Modification 1 Loreto Kirribilli – Alternations to the built form (SSD-7919-Mod-1)  
**Request for Additional Information**

I refer to application, Modification 1 – Alterations to the built form Loreto Kirribilli (SSD-7919-Mod-1), at 85 Carabella Street, Kirribilli. After careful consideration, the Department is requesting that you provide the following additional or amended information to enable assessment of the application:

Figure 4 Photomontage of development, as proposed to be modified
Source: FJMT

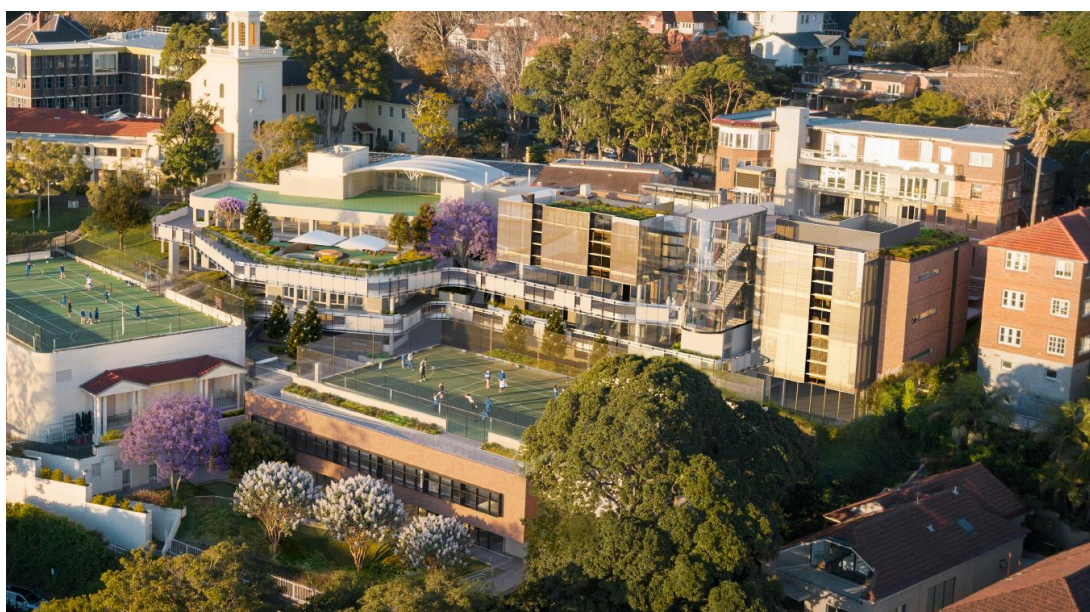
- The photomontage submitted as part of the Design Report does not correctly reflect the roof top plant room envelope over the amended innovation centre. A high balustrade appears to be proposed at the roof level. The plan / elevation and photomontage for the innovation centre should be consistent with each other.

DRAWING NUMBER	REVISION
C02.01	3

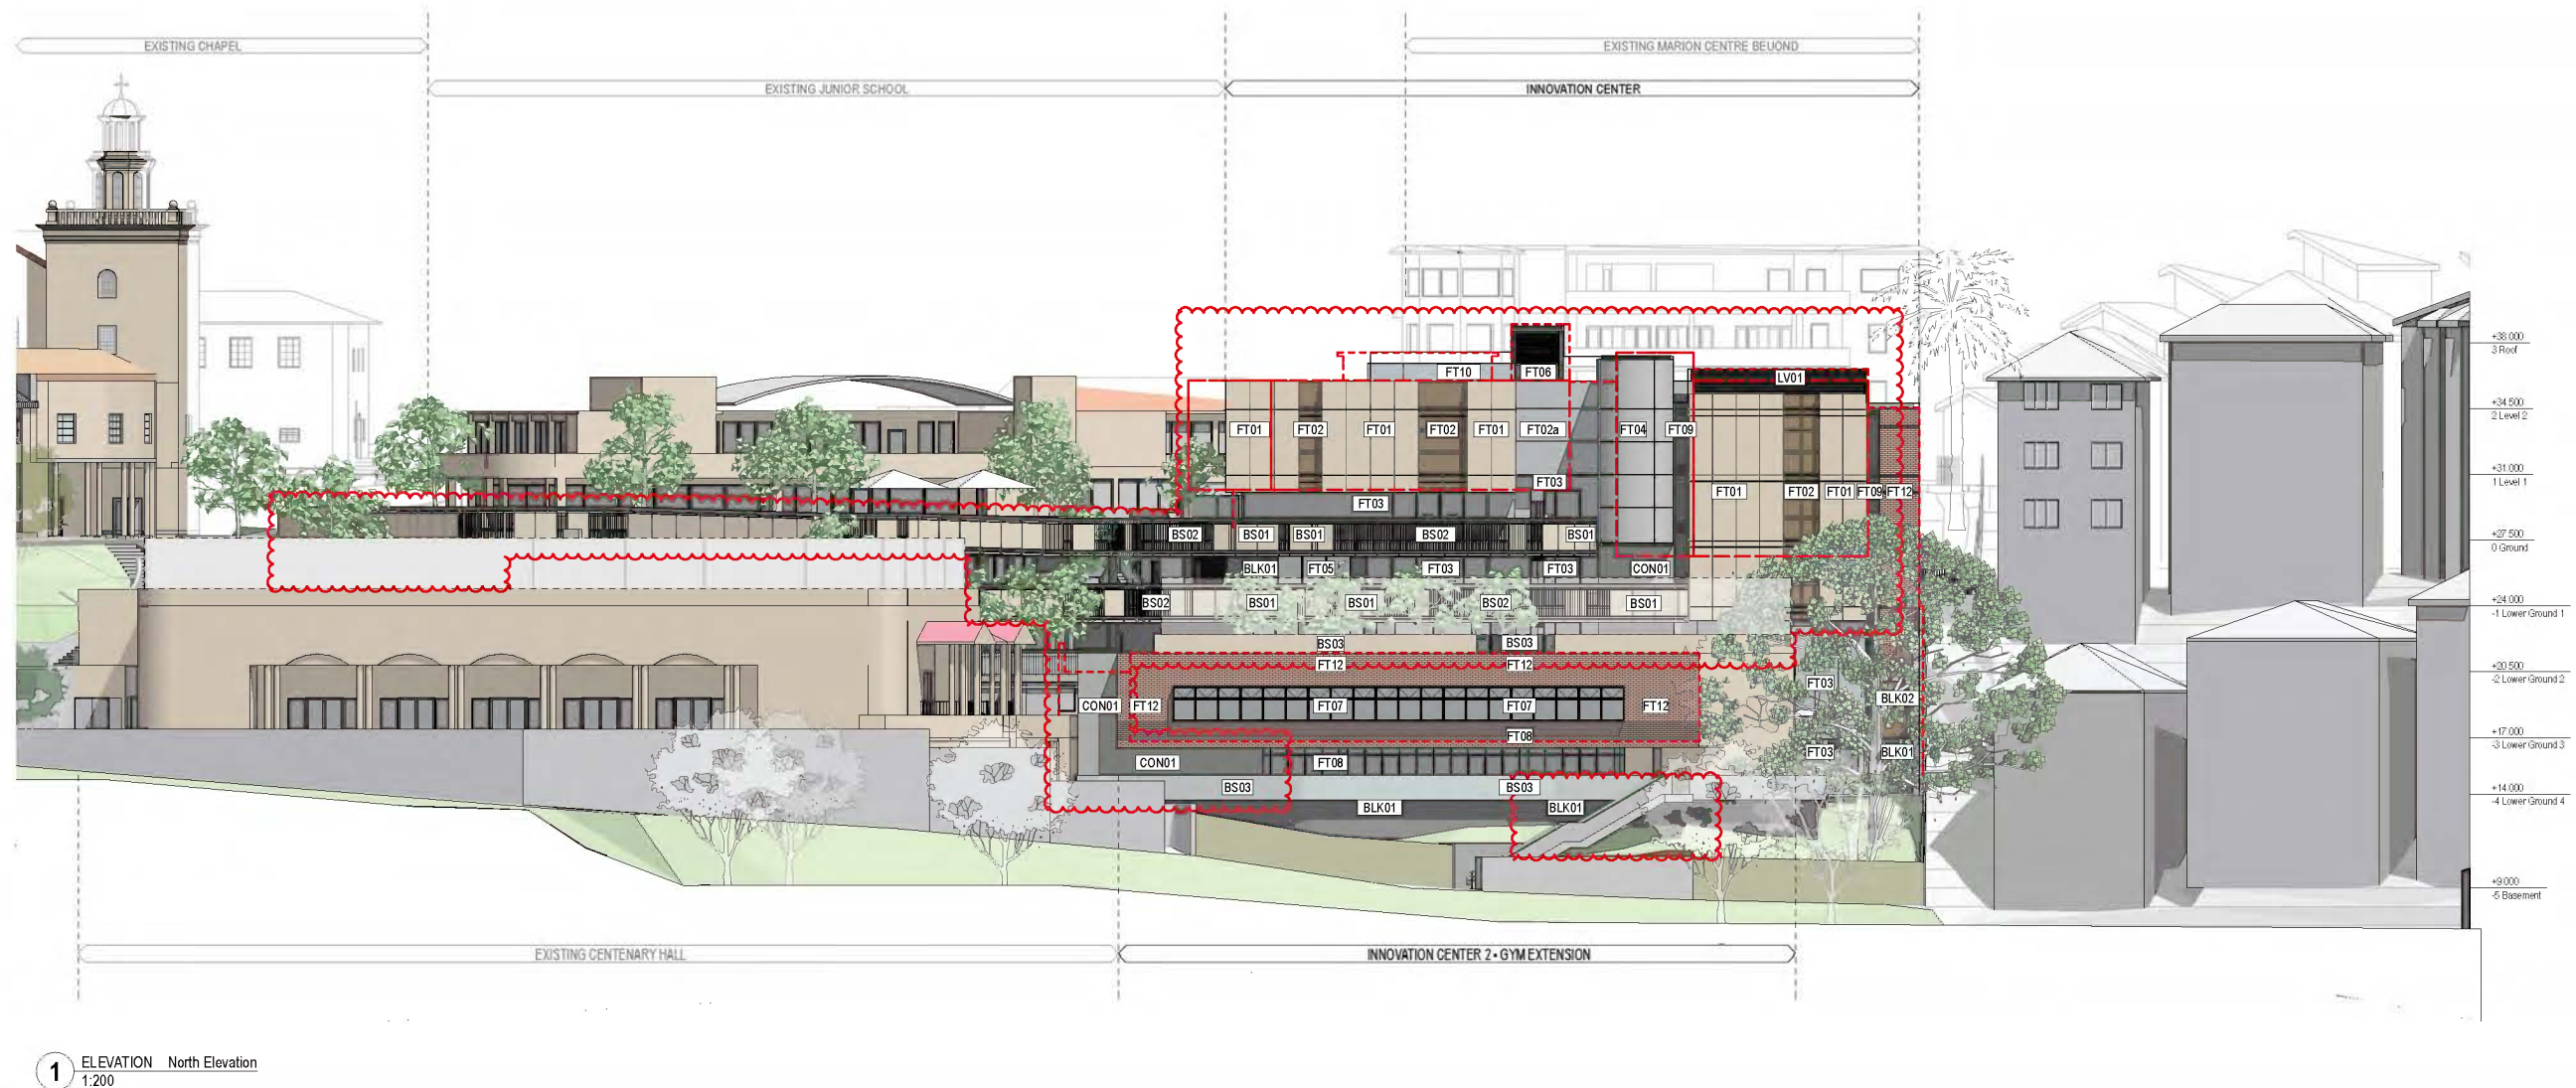
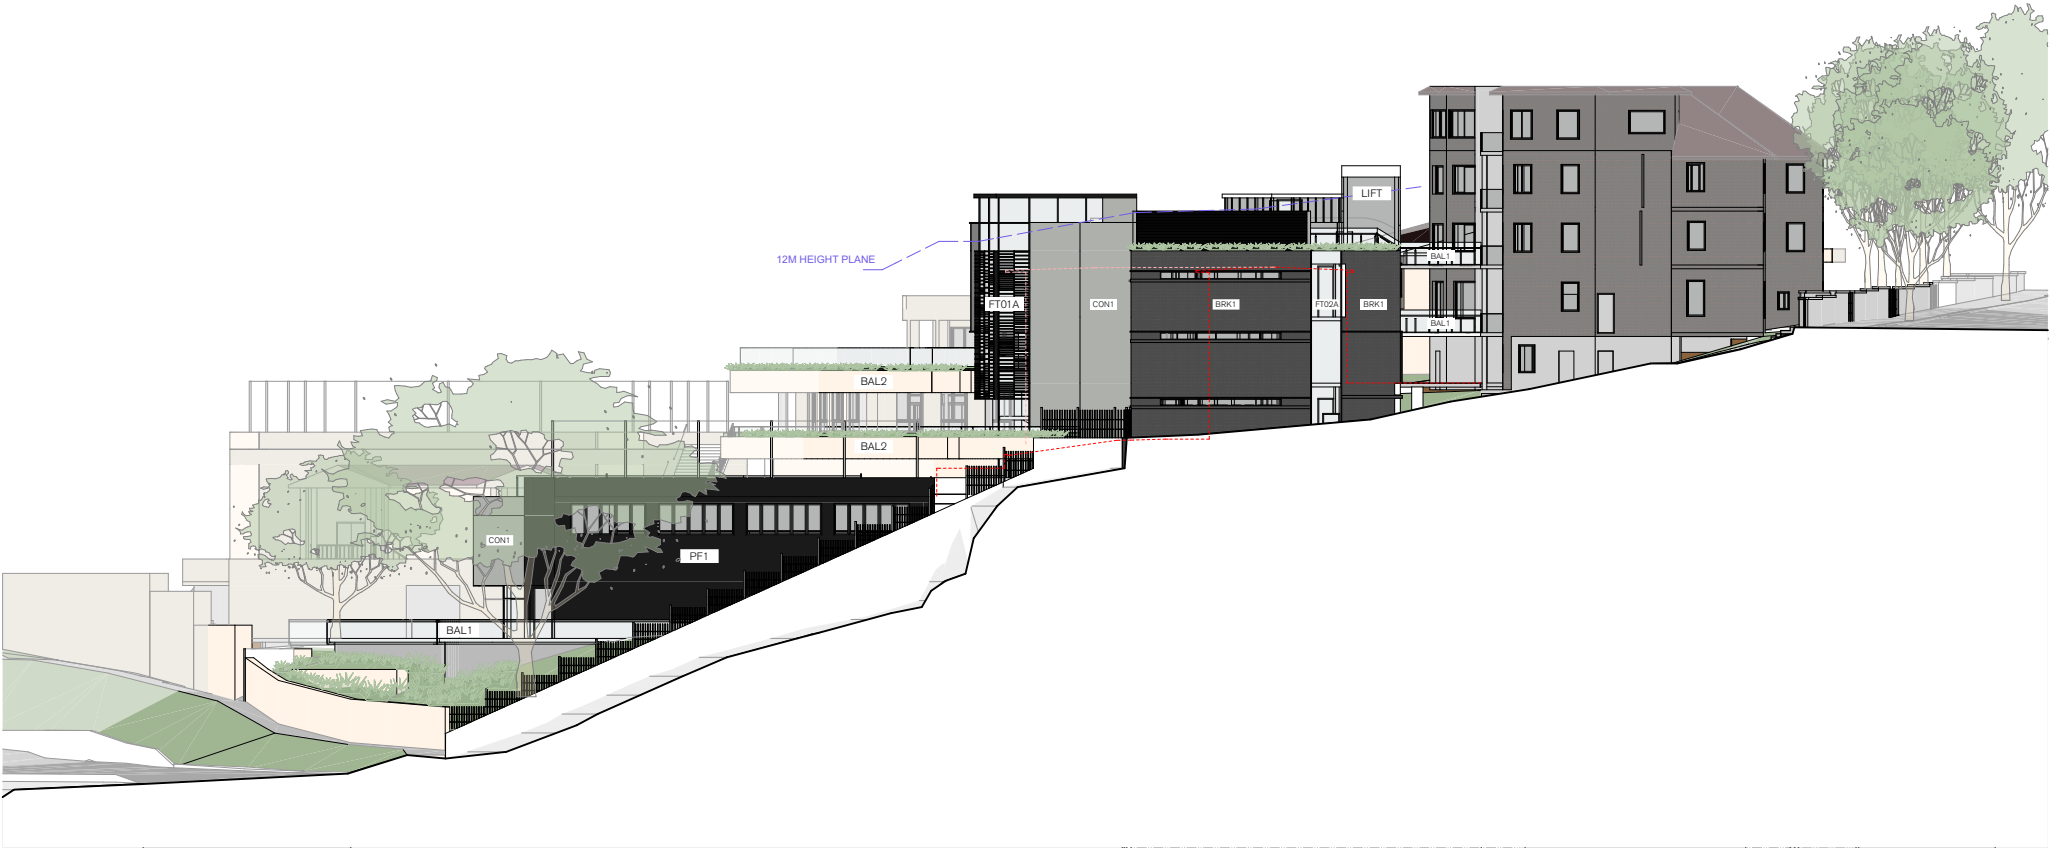
- The submitted western elevation for the innovation centre indicates that the sizes of the window openings have been increased. Additionally, a number of these windows would now be part of the learning studios / studio workshop areas, whereas previously these areas were used for storage (not habitable). Additional sight line diagrams / privacy analysis is required to demonstrate that the amendments to the sizes of the windows would not have additional impact on the adjoining neighbours to the west.
